DESIGN REVIEW: PEMULWUY DEVELOPMENT (Precinct 3) - Col James Student Accommodation

This report has been prepared by the Design Review Panel (DRP) for the Pemulwuy Development (Precinct 3) – Col James Student Accommodation.

The DRP endorses the proposed development by Turner and Scott Carver and confirm that in the view of the Panel, design excellence has been achieved.

*Location of landscaped ground level courtyard*

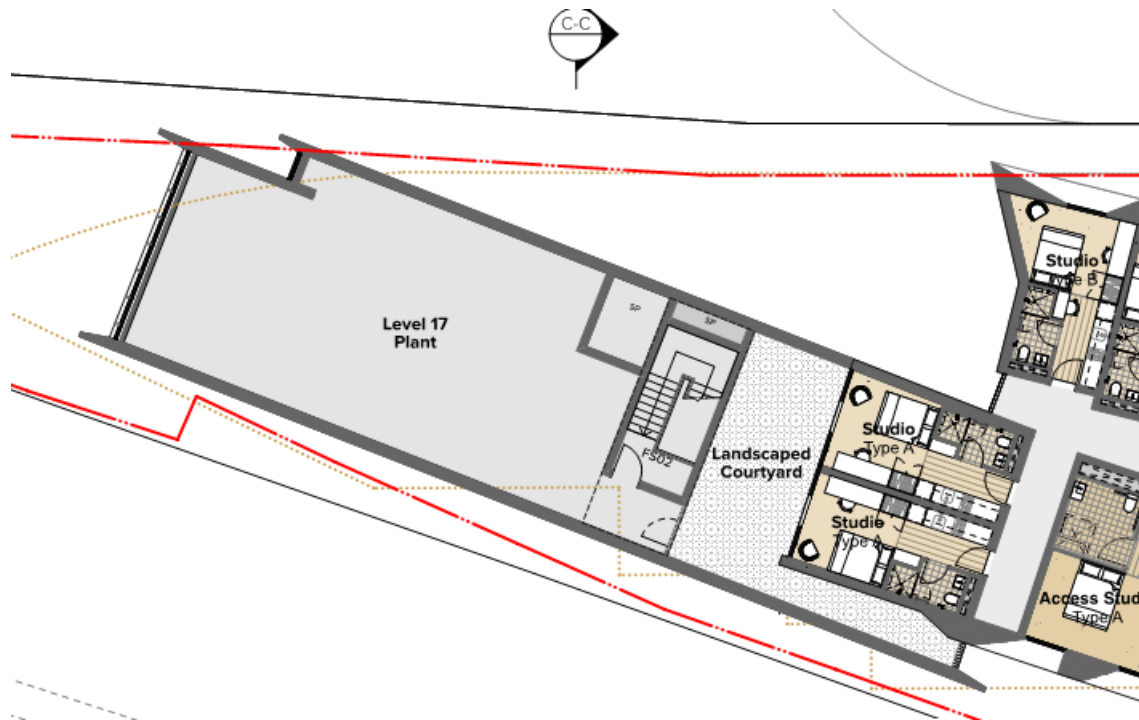
- The retention of the existing art wall along the rail tracks is supported – removal of metal fencing above is strongly recommended.
- Change the Level 17 Landscape Courtyard (adjacent to the FS02) and two Studio type A to match the layout (including corridor) of Studio type A and type F in the same location on Level 15.
